BRYAN G HALL

Project Name:	Proposed Mosque and Madrasa, Healey Lane, Batley				
Client:	Healey Islamic Trust				
Subject:	Technical Note – Response to Highways Comments (14 February 2025)				
BGH Reference:	21-382-006.02 (Local Planning Authority Reference: 24/93156)				
Date:	May 2025				
Prepared by:	D McLean	Checked by:	G Bowman	Overview by:	M Crabtree

DRAWING REF: 20185-D02-A **REV:**

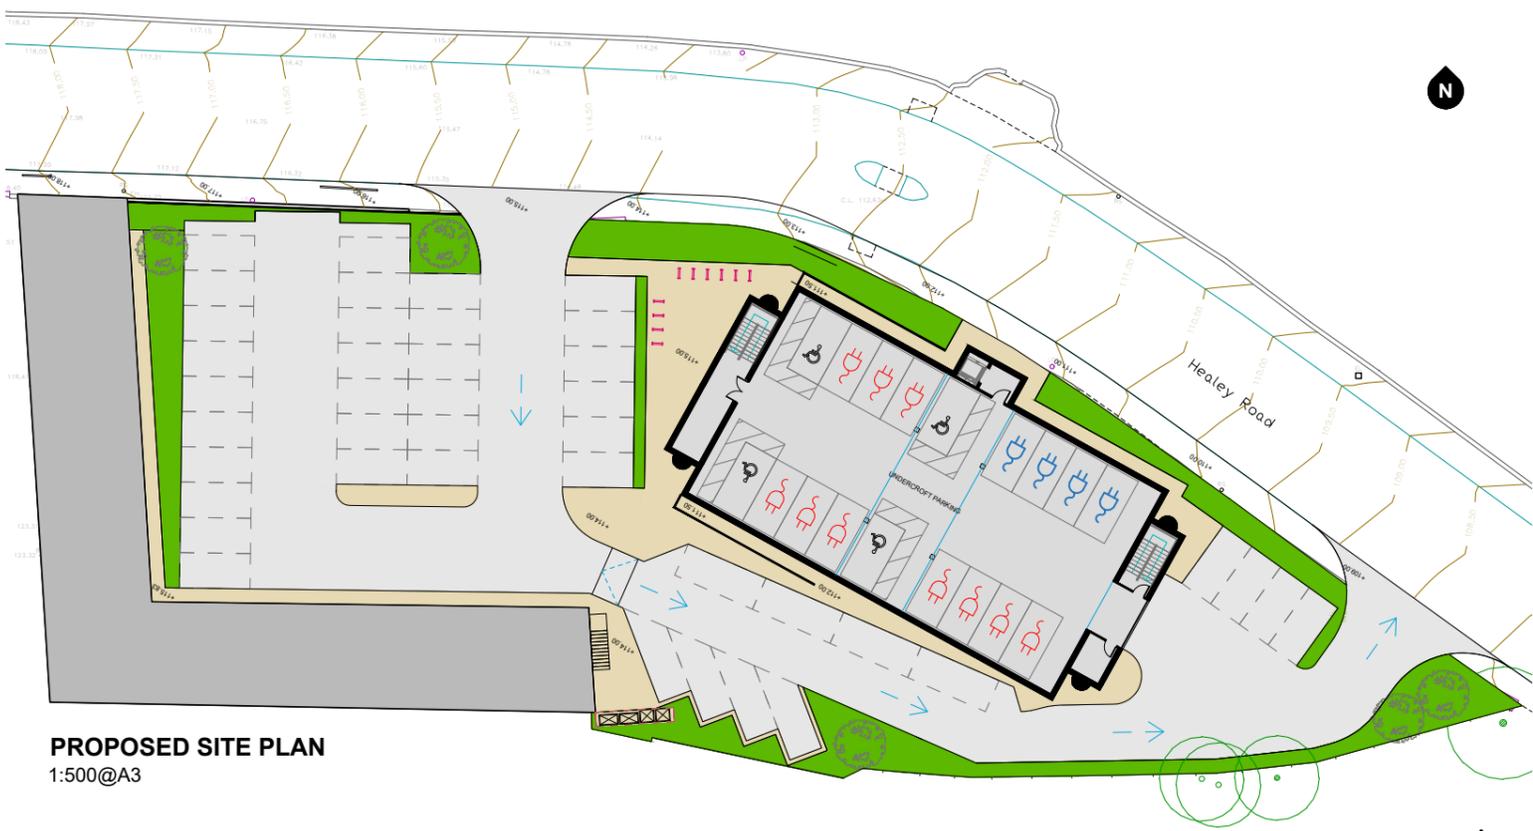
They have also expressed a concern that the drop-off and pick-up for the madrassa part of the proposed development may not be suitable as the volume of vehicles will need to queue on Healey Lane causing obstruction to other vehicles using Healey Lane and because of this you may need to provide additional information to show the capacity of the drop-off spaces, how they will be managed and how obstruction of Healey Lane can be avoided during these times.

14. The proposed development will accommodate 252 worshippers. This would generate a total parking demand of 115 spaces. The proposed car park will provide 59 spaces which is an increase of 33 spaces compared to the existing car park of 26 spaces. The remaining 56 vehicles will park on-street which is an increase of only 7 vehicles compared to the existing situation. This is a negligible increase which will not be noticeable on the local highway network. Every effort has been made to maximise the number of parking spaces within the site and it is considered that an increase of 7 vehicles is acceptable and can be readily accommodated on the surrounding streets during peak demand which only lasts approximately 30 minutes on a Friday lunchtime.

15. Concerns were also raised by Kirklees Council Highways regarding the pick-up and drop-off area. The pick-up and drop-off area will provide 8 car parking spaces. It was explained in the Transport Statement that was submitted in support of the application that based on an assumed dwell time of 5 minutes, that each space could accommodate twelve cars per hour, which equates to 96 five minute slots in total. It is considered that this is sufficient for drop-off however upon reflection dwell times may be longer for pick-up and the concerns of Kirklees Council are therefore acknowledged. It is important to note that the pick-up and drop-off spaces are only to be used during madrassa hours (evenings) and outside of

madrassa hours these spaces will be available for standard parking such as during Friday prayers.

16. The fact is that the remainder of the car park aside from the pick-up and drop-off area is to be used mainly by worshippers attending the masjid to pray. The masjid have confirmed that there is no overlap between the masjid and madrasa elements of the existing and proposed development. Therefore, most of the car park will be empty when pupils are entering and leaving the madrasa. Therefore, the remainder of the car park can be used by carers waiting to pick up or drop off children passing to or from the madrasa. This will ensure that there will be no queueing on Healey Lane. The drop-off and pick-up spaces are dual purpose and the car park will be marshalled by staff at madrassa times to ensure efficient movement of vehicle in and out of the car park.
